Subject: RE: Planning Consultation on: AL/80/21/DOC

Engineers Comments Regarding Surface Water Drainage

Application No: AL/80/21/DOC

Description of Works: Approval of details reserved by condition imposed under ref AL/59/19/HH relating to Condition No 4 - surface water drainage.

Dwg No: PL/03

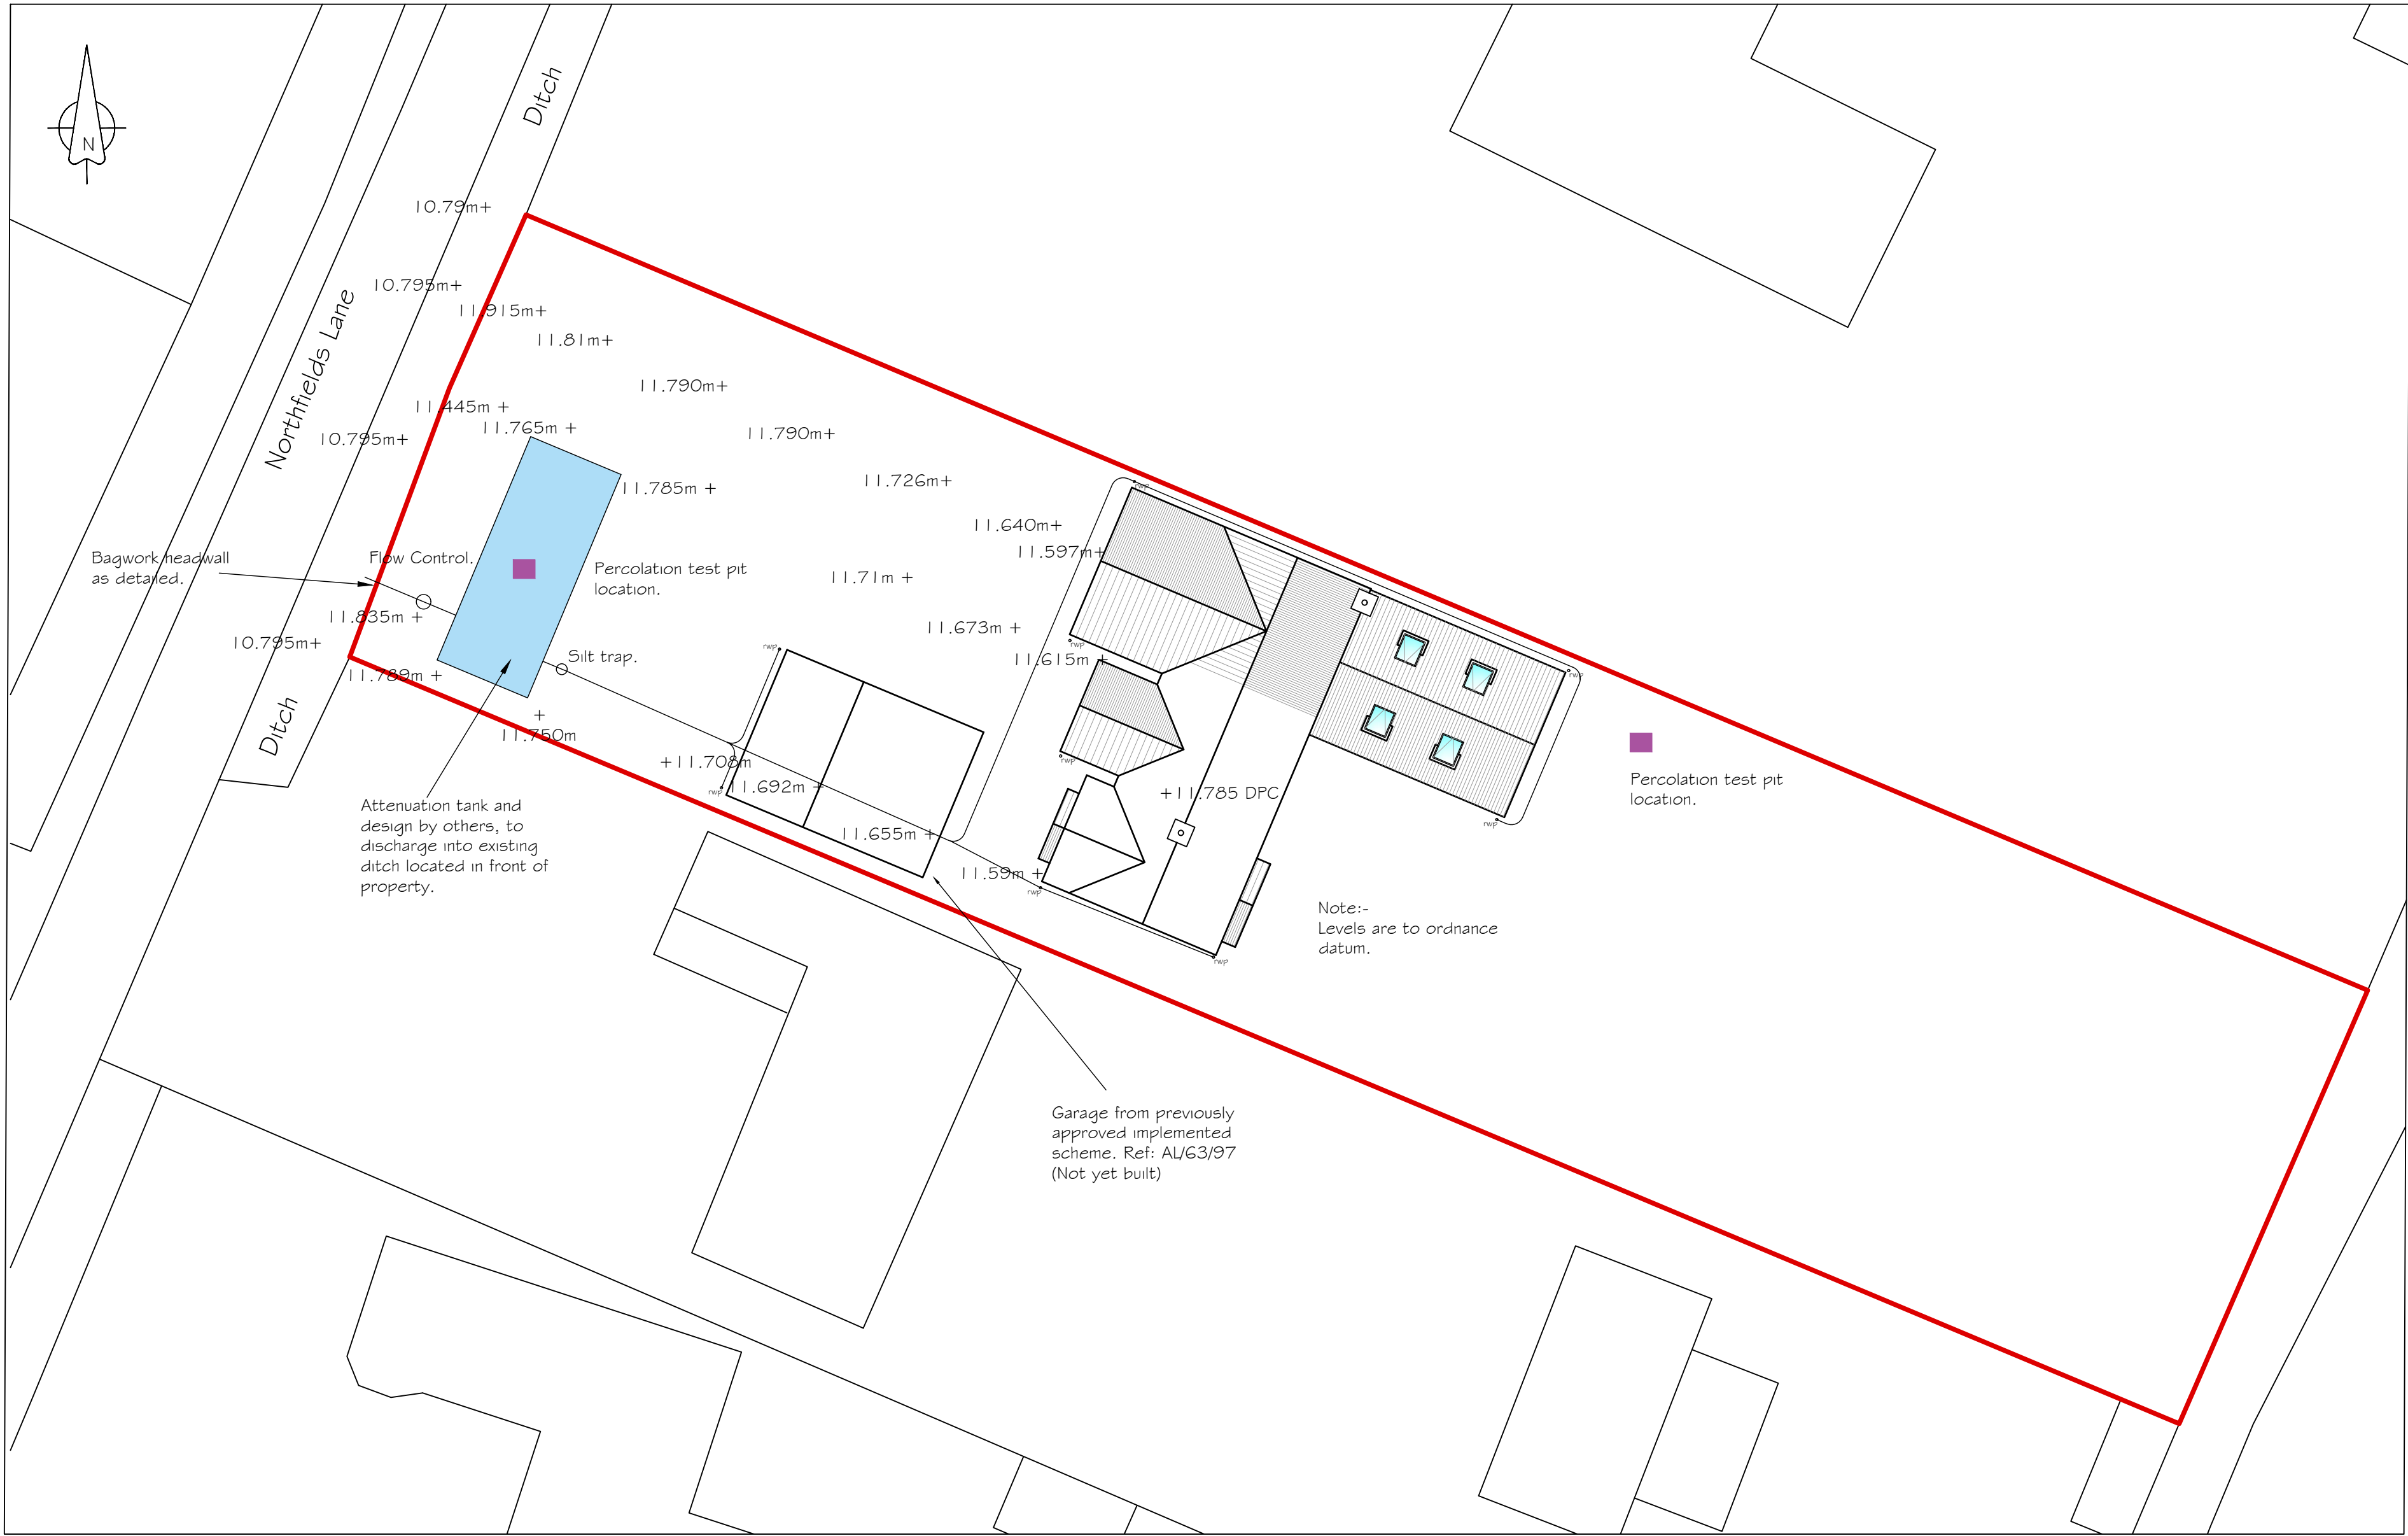
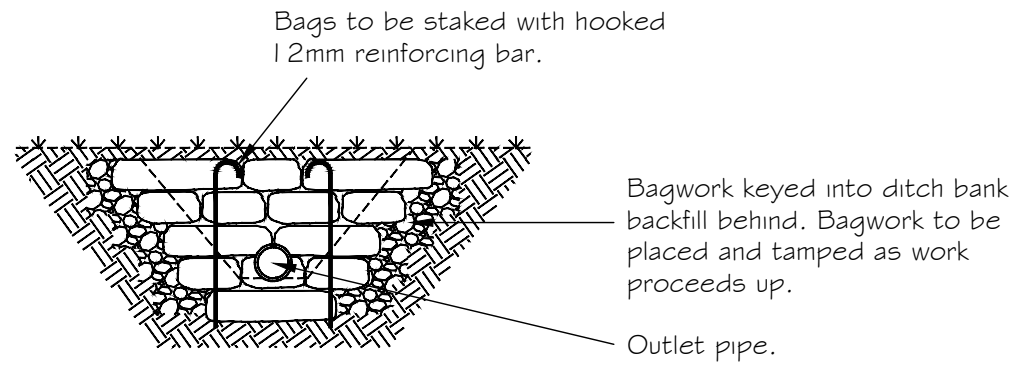
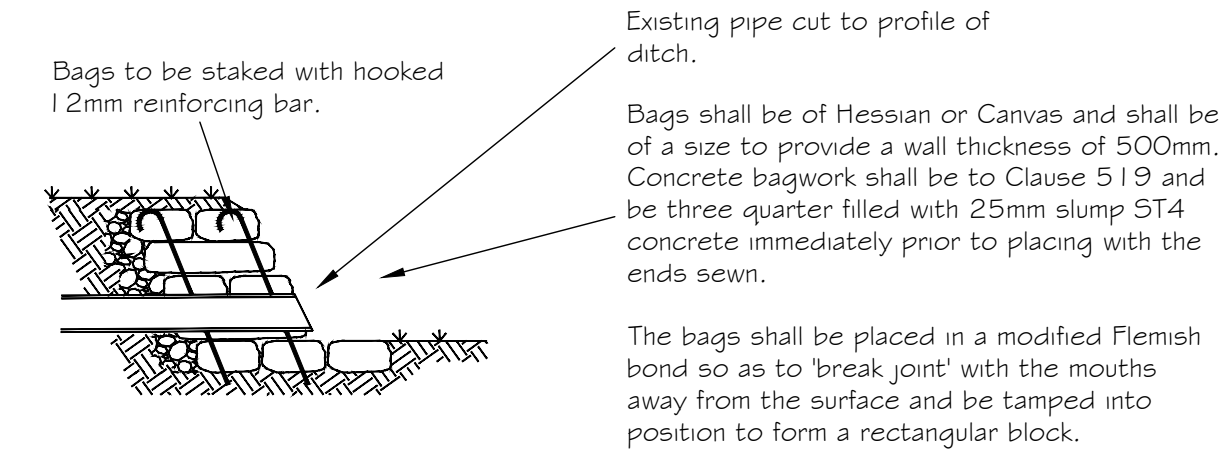
4. The drainage layout requires further detail, please label attenuation crates, silt trap and flow control with invert levels, cover levels and sump levels where appropriate. Please also label the restricted flow rate, design head and the product number on the flow control. Please encase all pipes in concrete as cover depth will be less than 600mm.

5. Hydrobrake detail should include invert level, cover level, incoming and outgoing pipe diameters and sump depth (min 300mm).
6. Headwall construction details should include hard bed, soft bed and top of bank levels. Invert levels of proposed pipes must be at least 150mm above the bed of the watercourse.

Please see Drainage layout Drawing, Stanwick-BPS PL03 Attenuation rev D (section through 1:100), SCL-0070-2000-0400-2000 Hydraulic Characteristics , SCL-0070-2000-0400-2000 Design Drawing

Please see Stanwick-BPS PL03 Attenuation rev D (section through 1:100 and typical headwall details). With the ditch being de-silted we should be able to achieve around 250mm fall between the invert of the outflow and the bed of the ditch. Subject to final bed levels being agreed with Paul Cann.

The consulting engineer has commented as follows: Typical bagwork headwall construction drawings are shown, exact detail regarding hard bed, soft bed and top of bank levels to be determined and agreed at point of construction once the ditch is cleared of vegetation and de-silted. Final ditch bed level to be agreed with ADC as part of ordinary watercourse application.

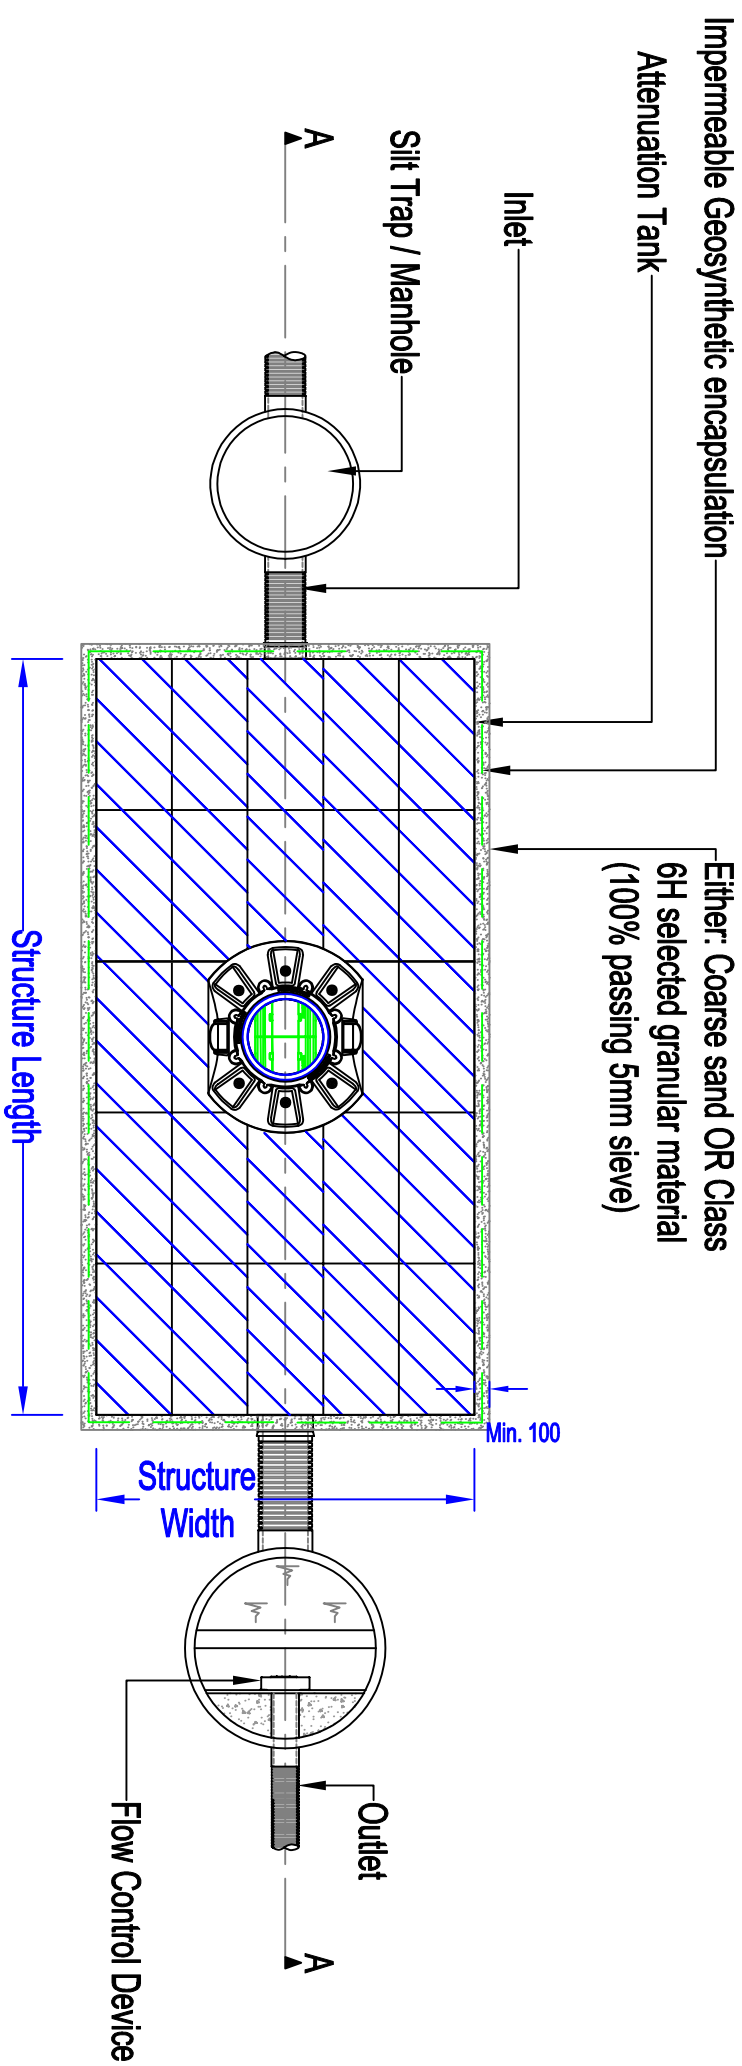
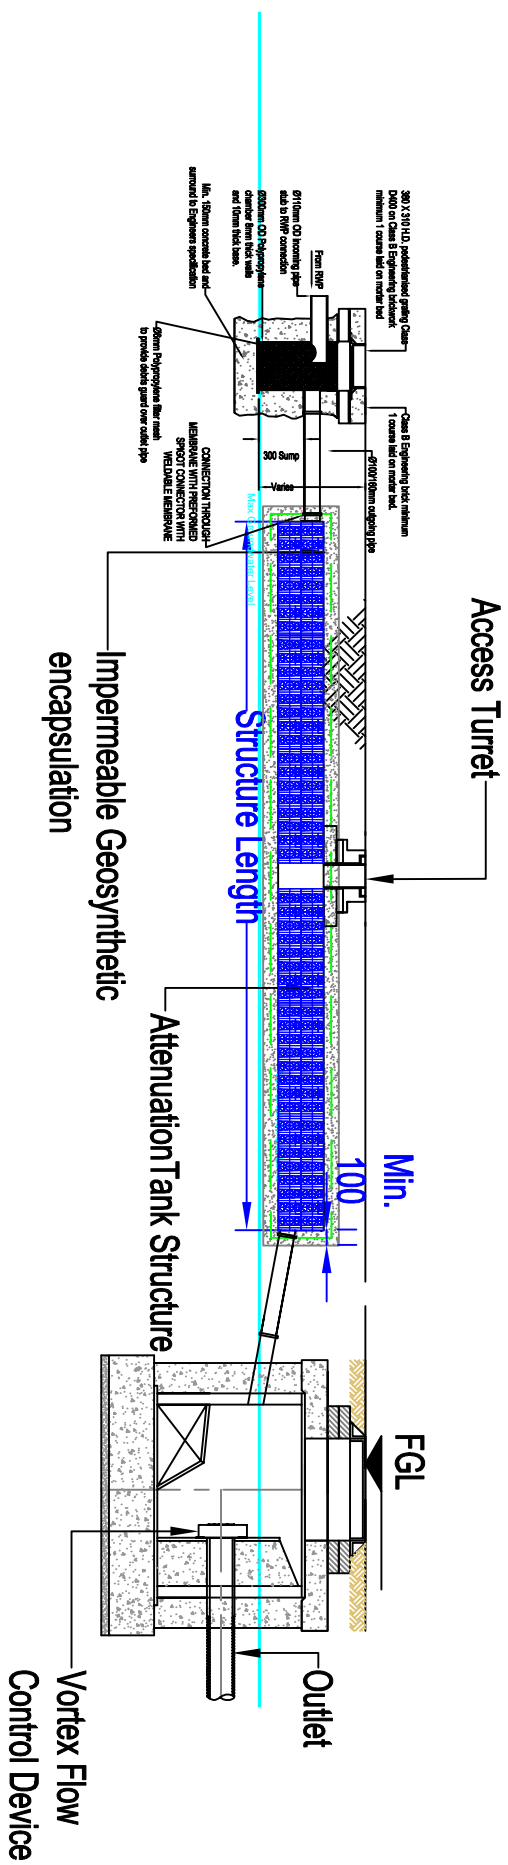
2. Please can the crates be lined with a **permeable** liner and the outflow set 50mm above the base of the tank. This will allow regular small scale events to infiltrate where possible but still ensure that high volume events can overflow to the watercourse. Within the current design there is capacity to do this and still attenuate 1 in 100 year event +40% above 500mm as there is spare storage capacity. If the capacity is reduced as a result of point 1 please ensure that the storage requirement can be met at 350mm depth. The invert level of the tank will need to be set above 0.8mbgl.

Please see Attenuation Design Drawing(400mm) – Permeable Rev3 (typical design showing permeable lining for crates and note showing height of outflow from the tank) , Attenuation Design (400mm) – Permeable Rev2 (showing reduced tank size which allows for infiltration with a 350mm effective depth) and SUDS Design Report Rev D page 4

SHE-0031-3500-0500-3500

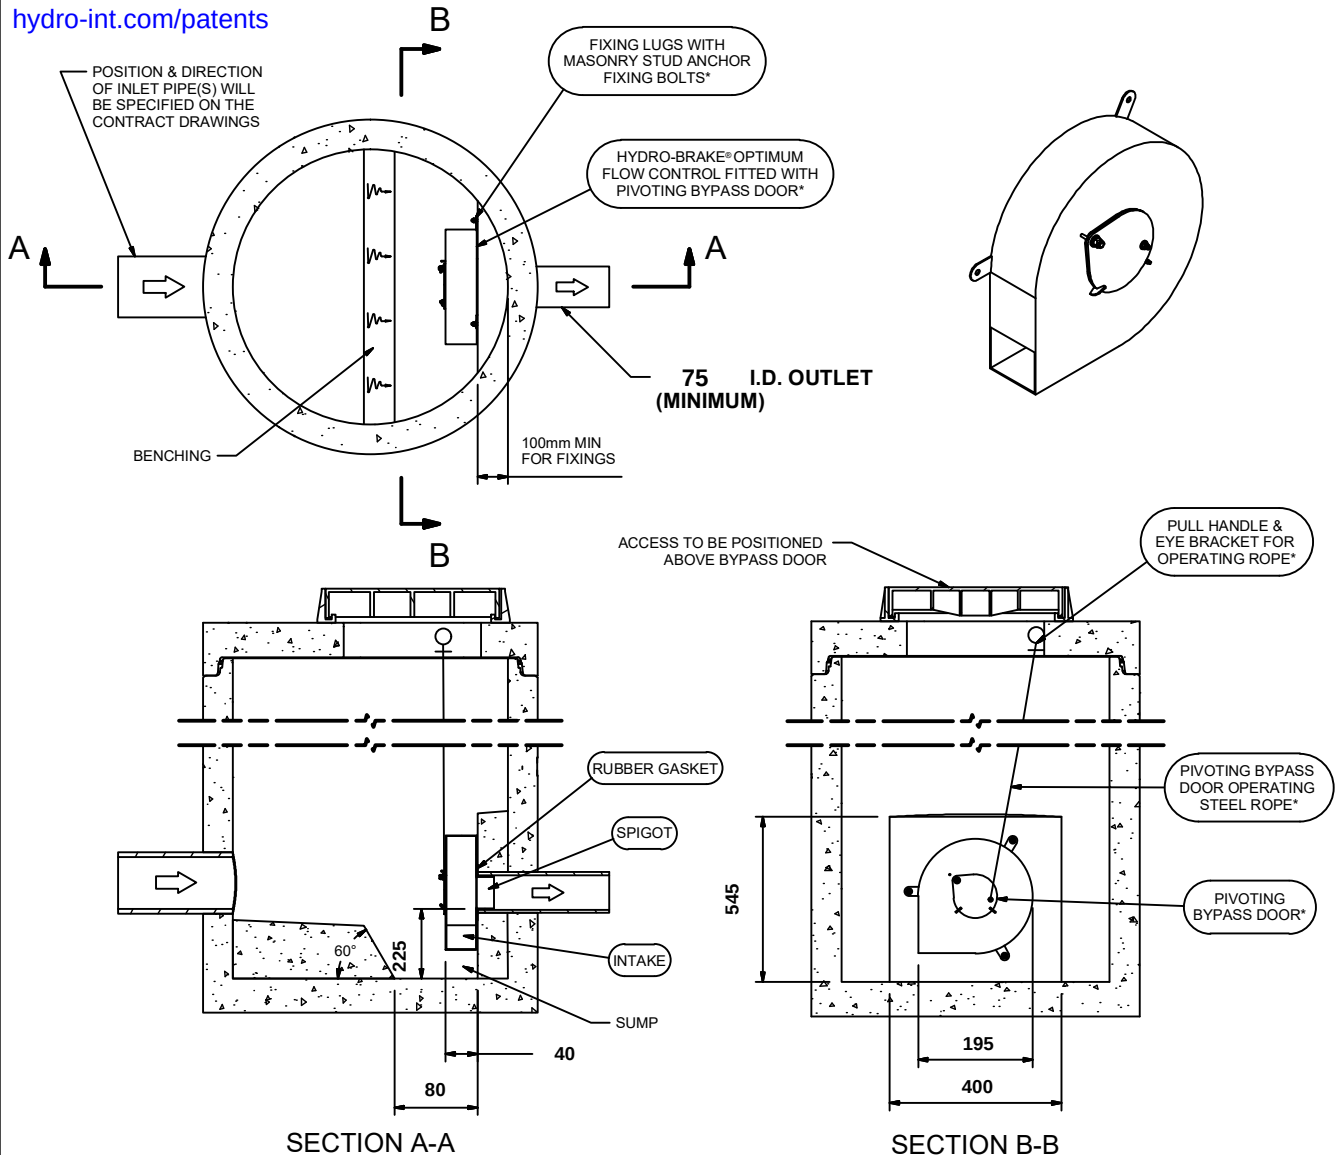
1. Please change the Hydrobrake to have a minimum aperture of 50mm. This will increase the discharge rate, we are happy to accept a discharge rate of 2l/s even though this is faster than QBAR for the site. We believe a lower discharge rate (and smaller aperture) will increase risk of blockage, and thus risk of flooding on site.

Please see SCL-0070-2000-0400-2000 Hydraulic Characteristics , SCL-0070-2000-0400-2000 Design Drawing. Please also see Suds Design report RevD page 3.

Please see SCL-0070-2000-0400-2000 Hydraulic Characteristics , SCL-0070-2000-0400-2000 Design Drawing, Pipe design calculations, SUDS Design Report RevD and Drainage Layout Drawing
